Interested Party BIOFUELWATCH IP NO 20032287 submits the following comments on the representation by the Environment Agency on Drax's BECCS application.

Interested Party BIOFUELWATCH IP NO 20032287 submits the following comments on Representation RR-141 from UK Health Security Agency (UKHSA) and the Office for Health Improvement and Disparities (OHID).

Interested Party BIOFUELWATCH IP NO 20032287 submits the following comments on the Representation by Natural England.

Created by: UKLDM002 - 2022-04-08 11:38:33 - \\uk.wspgroup.com\central\data\Projects\70072063\Drax BECCS DCO\03 Environment\09 Surface Water\04 WIP\Modelling\QGIS\Drax Flood Depth Maps_LM.ggz

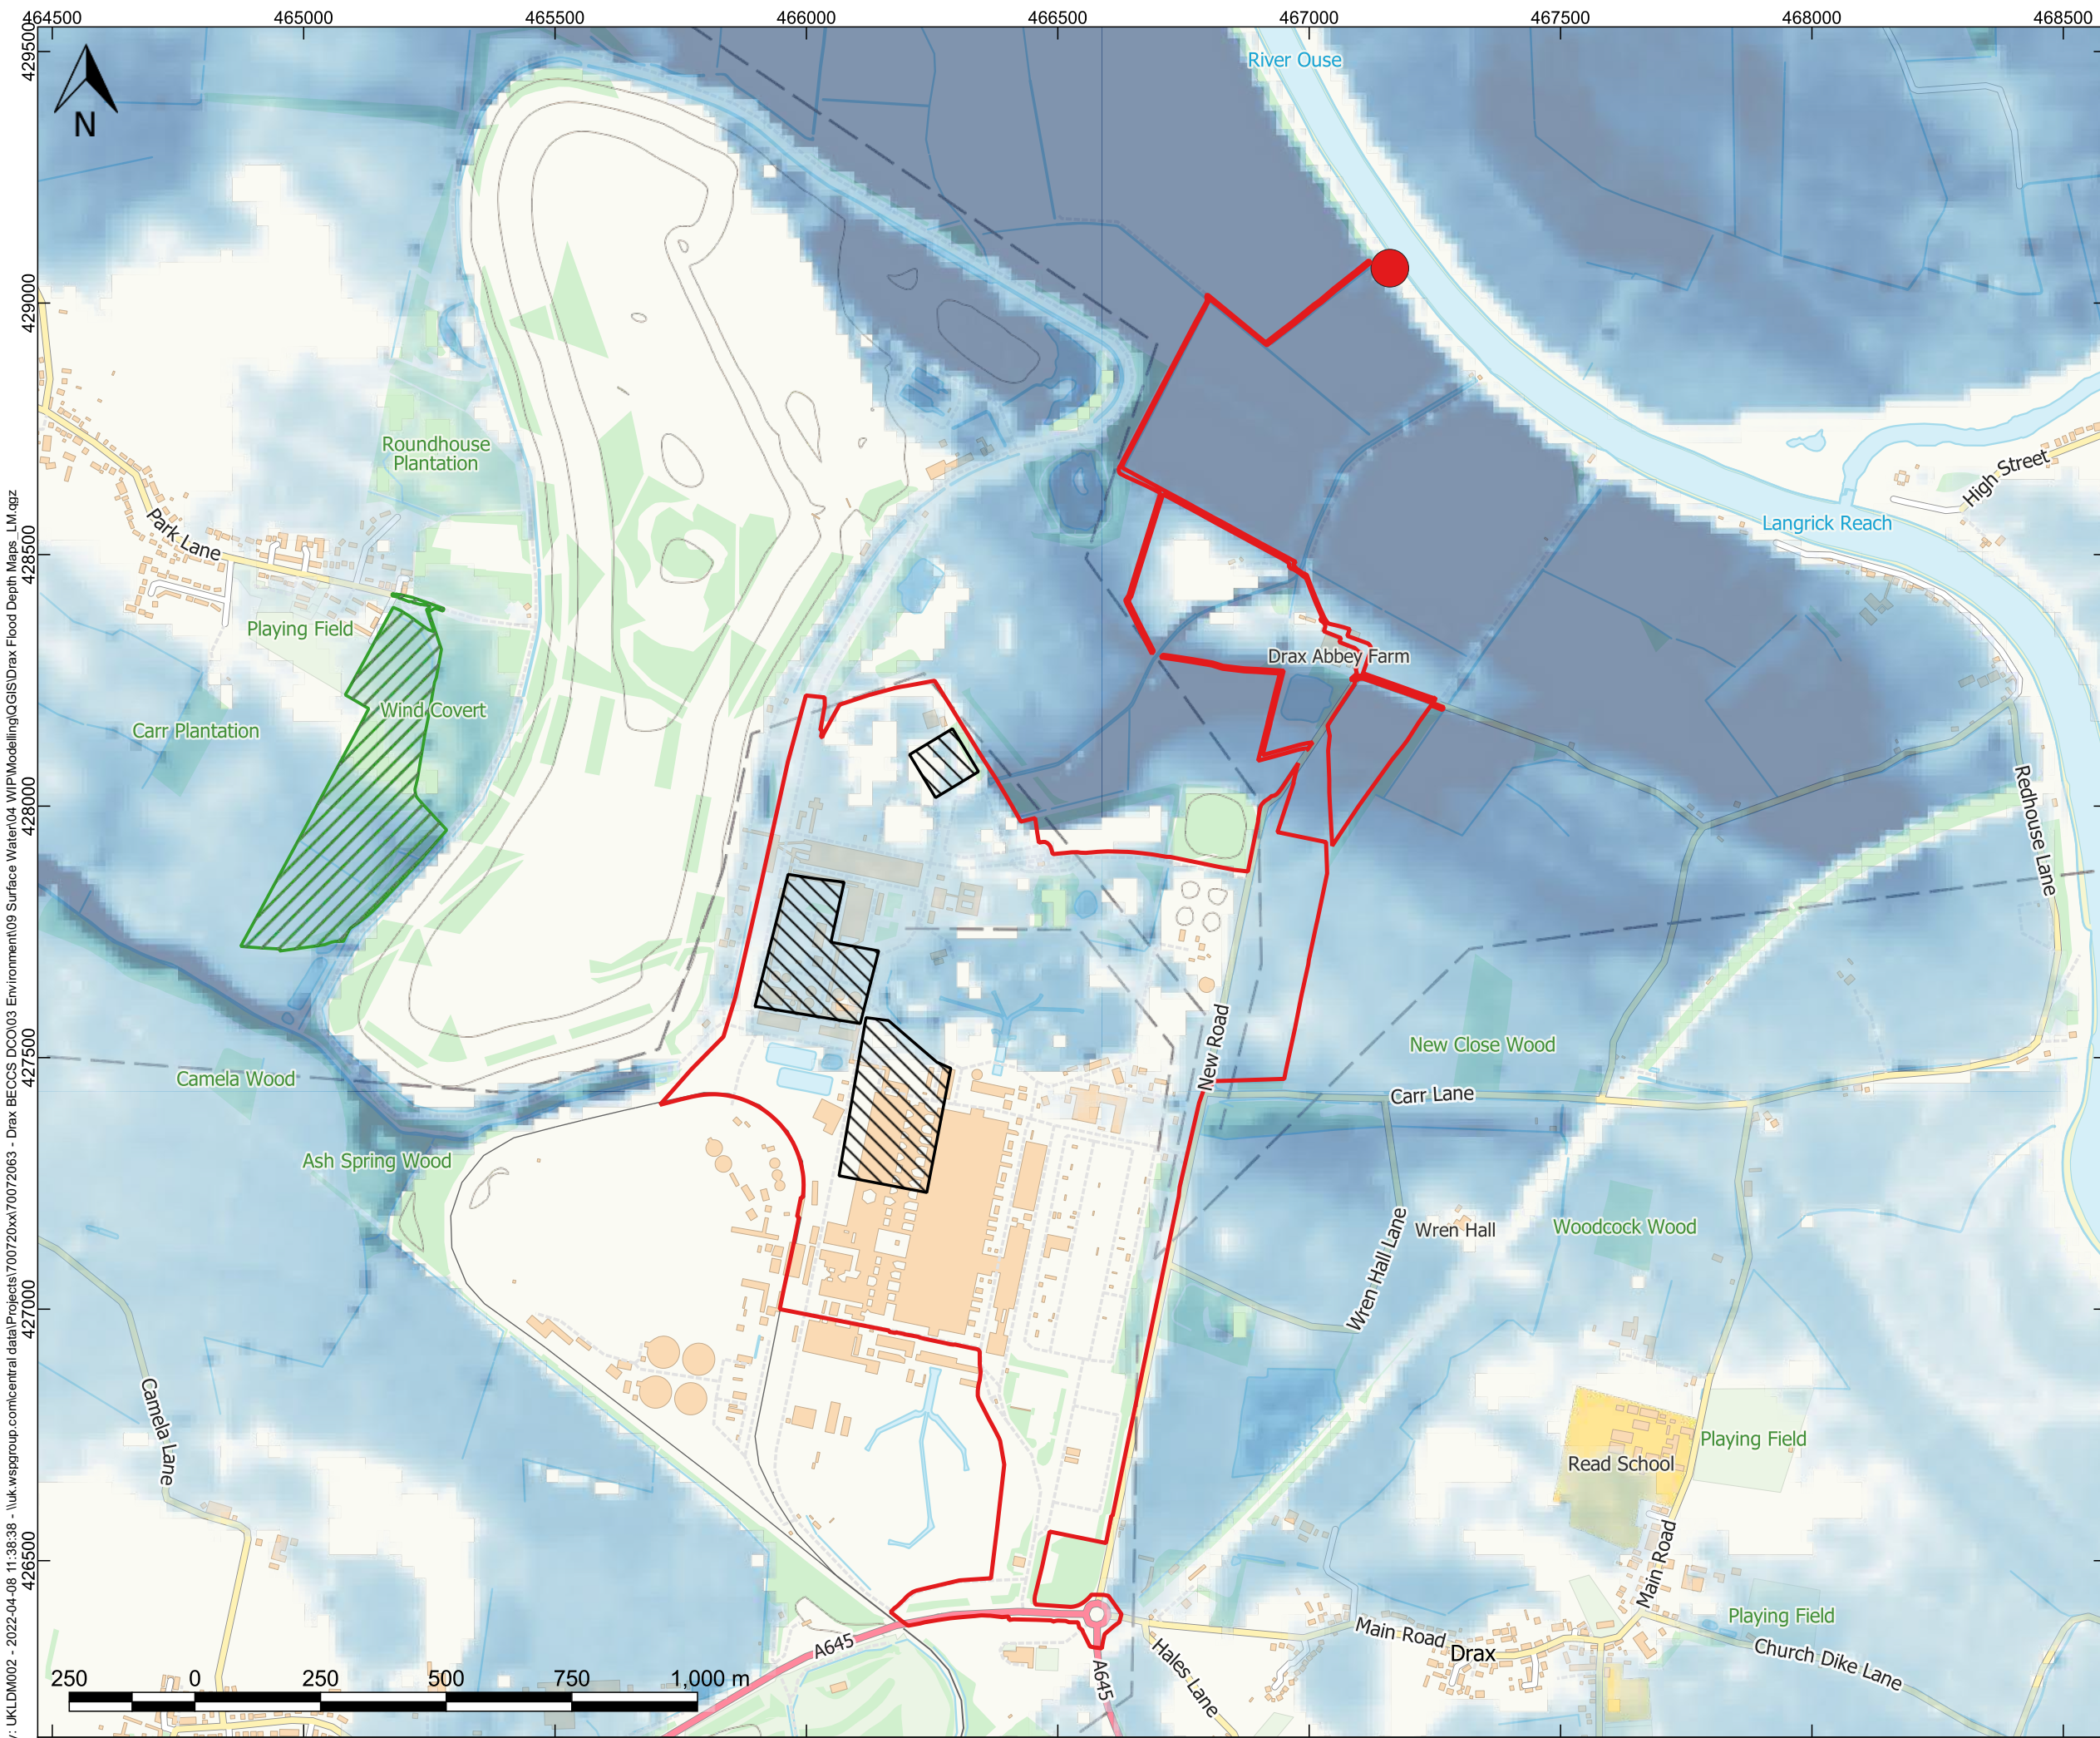
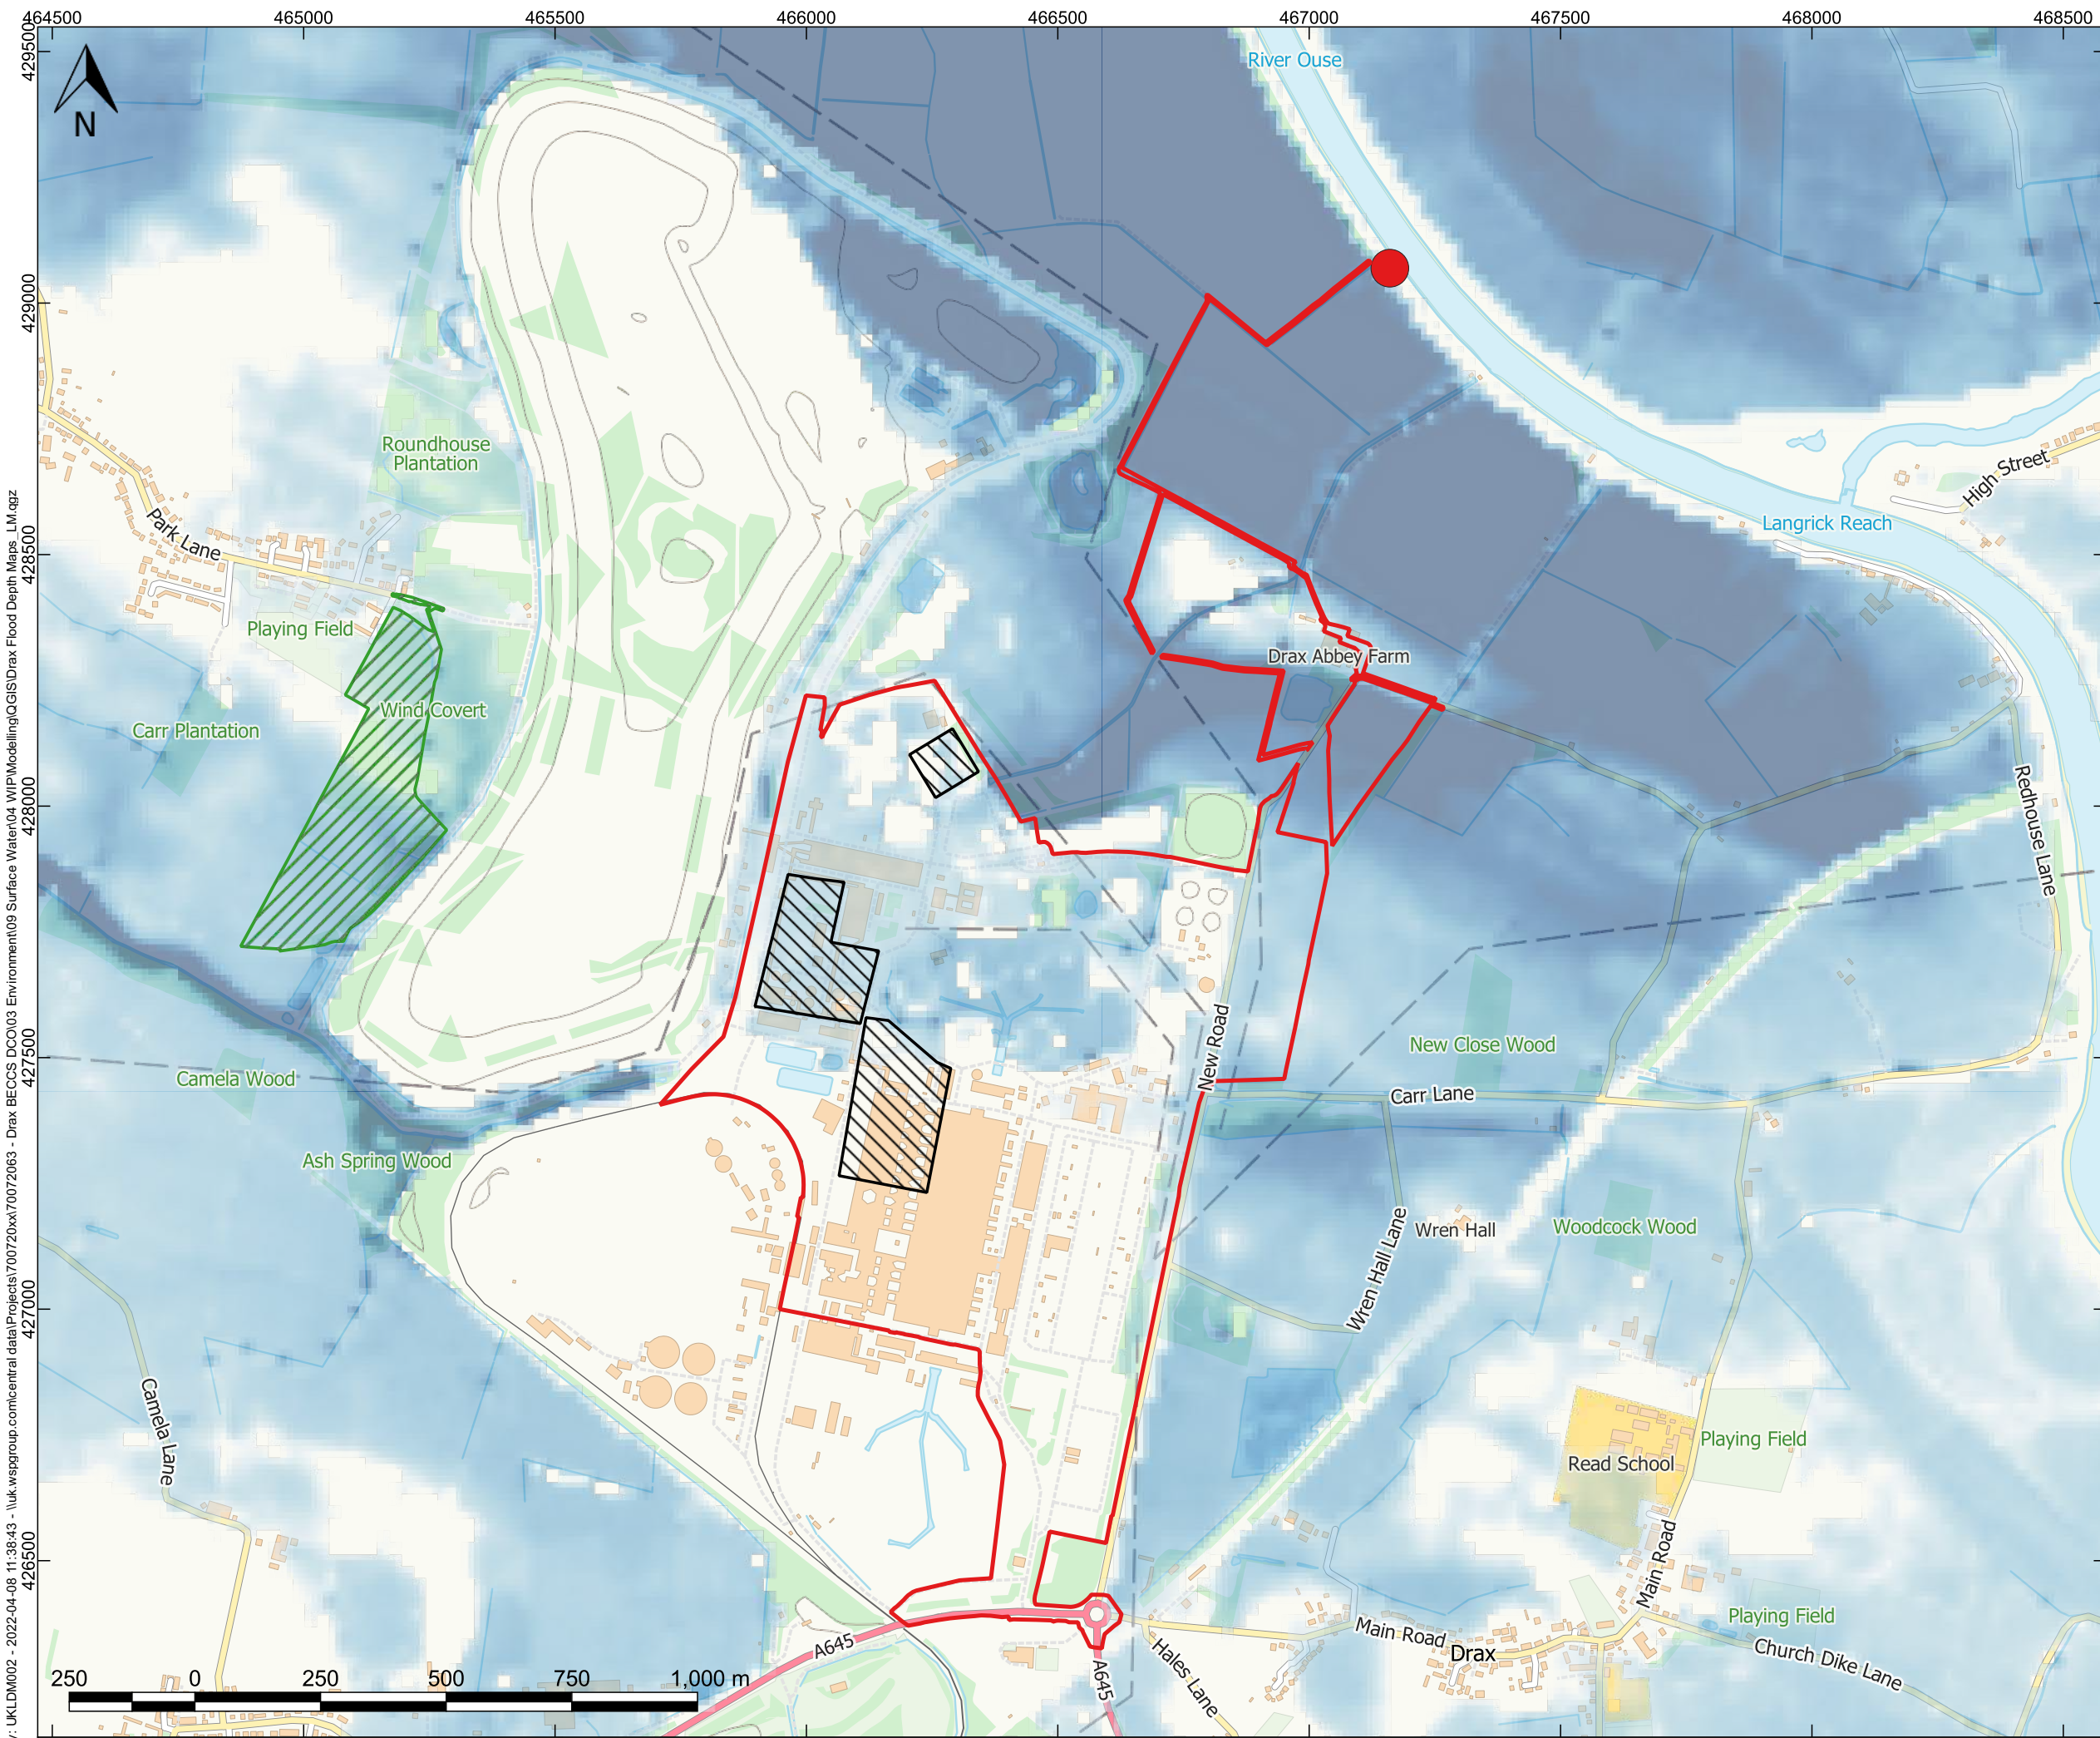
We understand that the applicant is currently in discussions with the EA to resolve outstanding issues around flooding, however, there are some pertinent issues to be raised. Firstly, the latest Climate Change Risk Assessment policy paper (CCRA 2022) advises that climate change adaptation must be integrated effectively into all new infrastructure and that “the evidence shows that we must be prepared for warming up to 4°C” (CCRA 2022: 3). This means an increasing flood likelihood of 44% by 2050 and 75% by 2080. The 4°C global warming scenario is not taken into account by the Flood Risk Assessment document.

We also note that scientists have raised the near term warming projections this year, as well as the proximity to tipping points which include polar ice and glacier melt (impacting on sea levels). To provide a realistic Flood Risk Assessment, these additional factors should also now be taken into account.
